Addendum No. 1

RE: Contract ID C203656

Macon County (B-3868)

Bridge #172 Over Little Tennessee River On SR-1456

04-Nov-2015 14:23 B-3868_RdL_psh_04.dgn

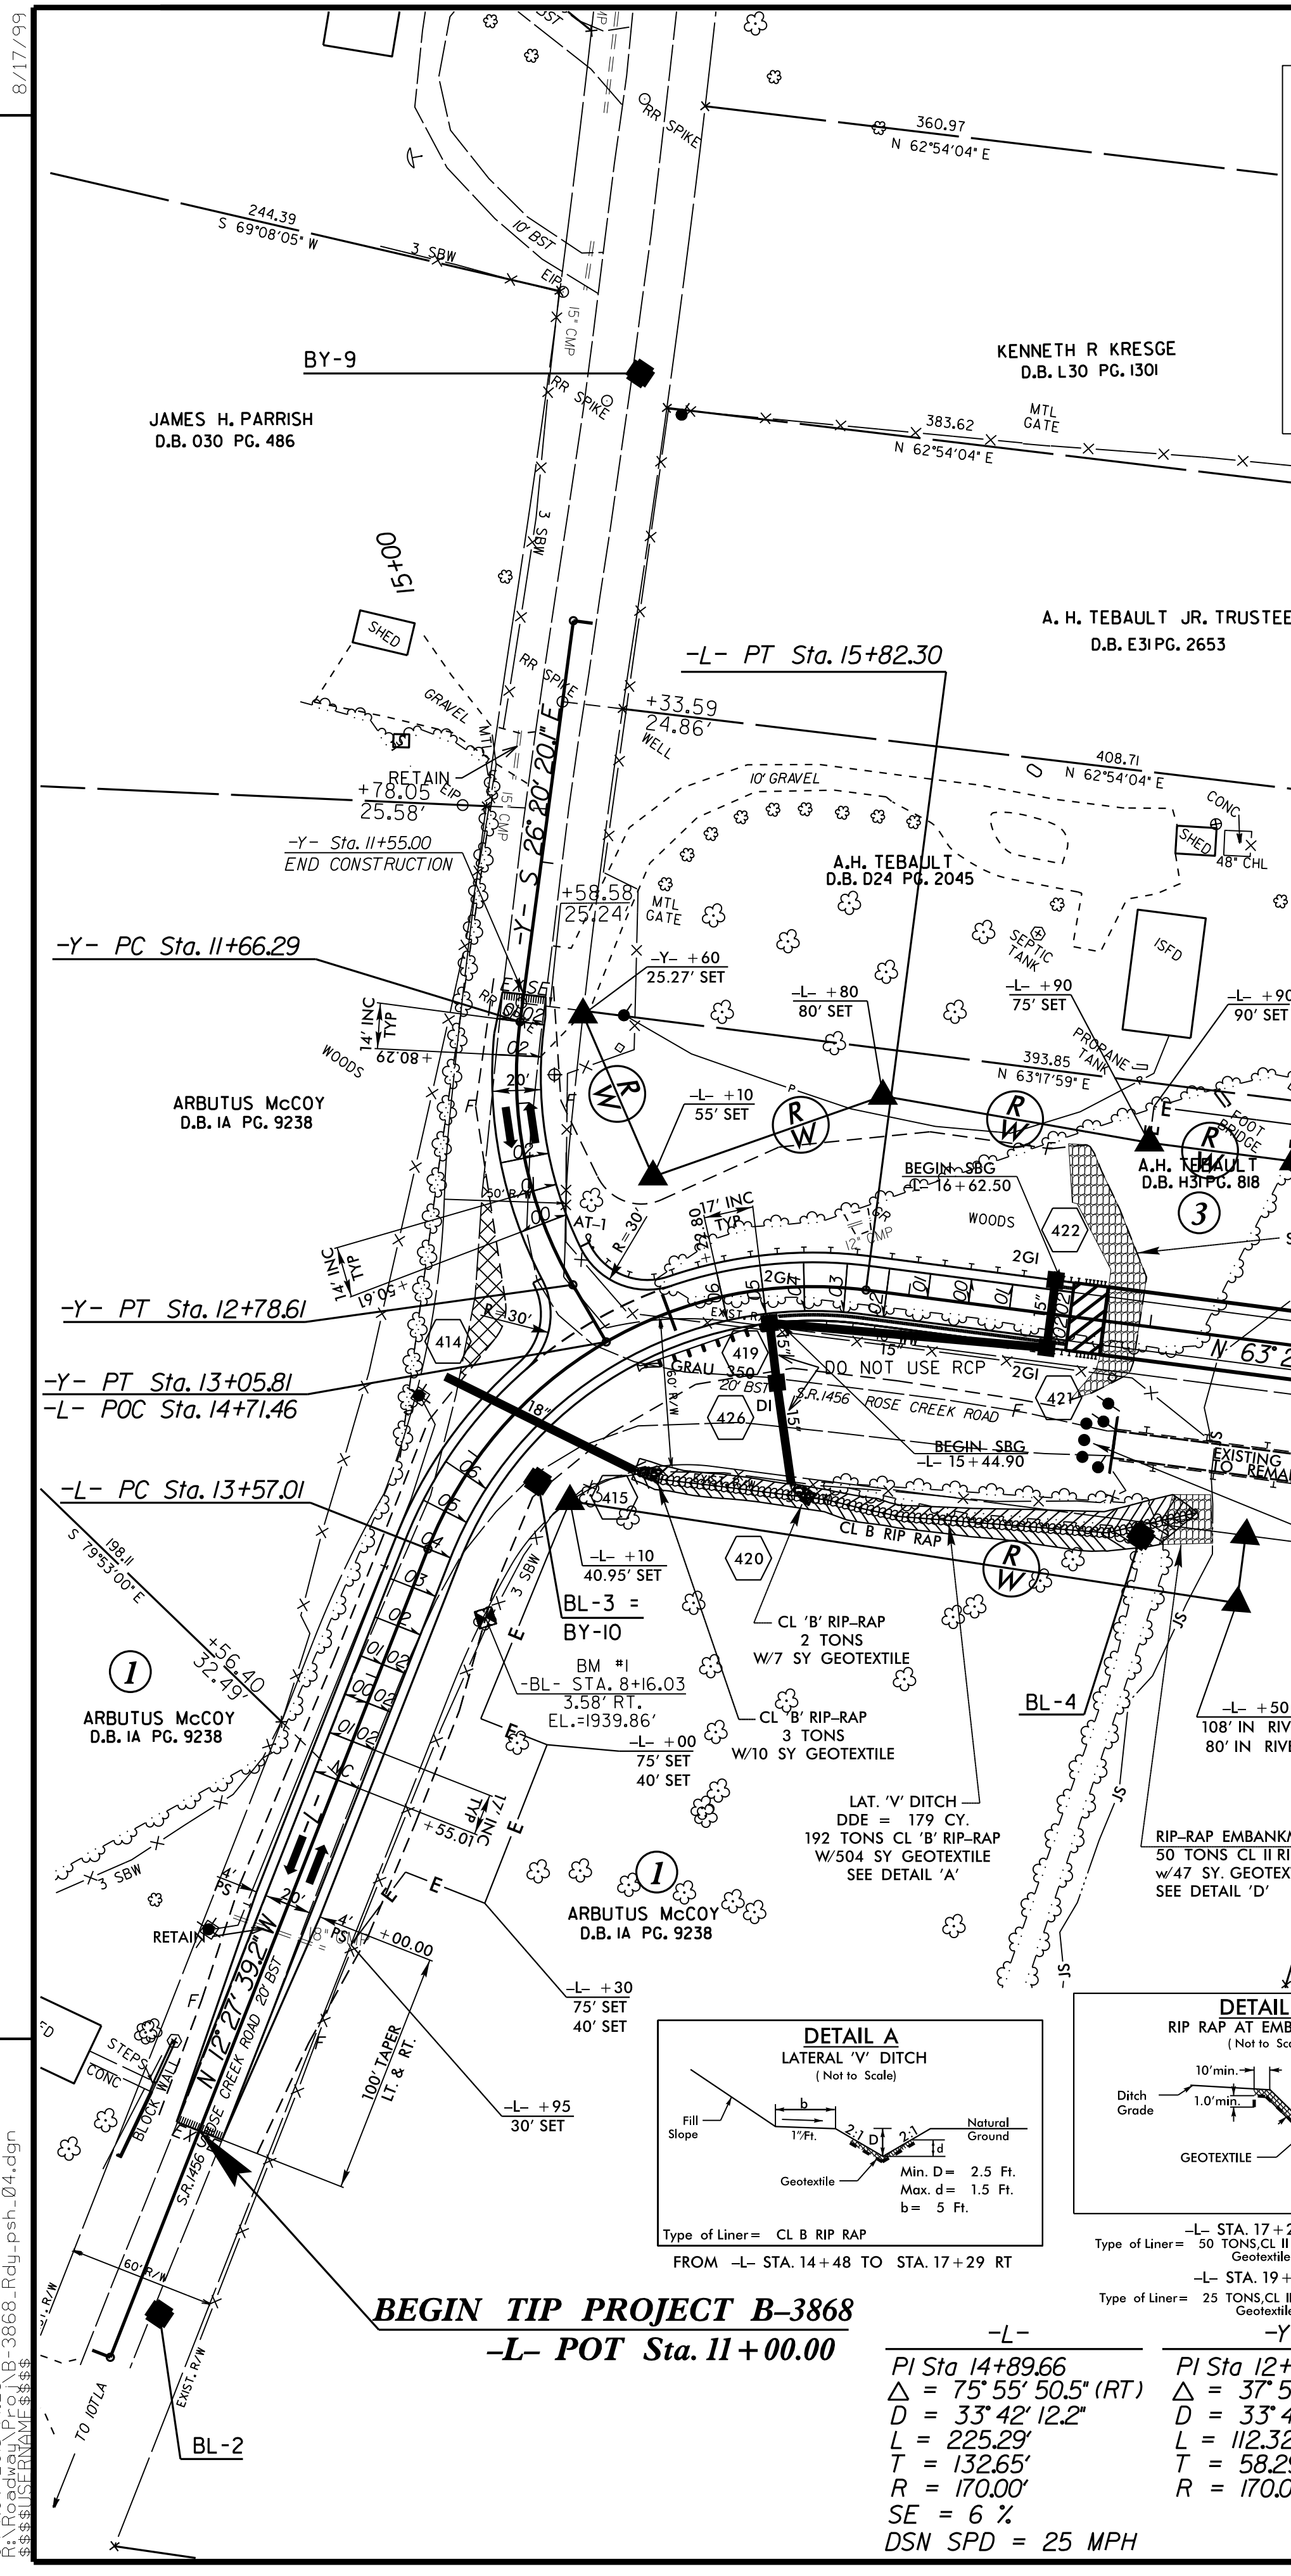
Sheet No.	Revisions
Roadway Plans Title Sheet	Revised the letting date to December 15, 2015.
1C-1	Some very minor changes were made to a couple of values in the "Survey Control Sheet"
4	Minor changes were made to two values along the right-of-way line as a result of the changes to the "Survey Control Sheet"
Structure Plans Title Sheet	Revised the letting date to December 15, 2015.
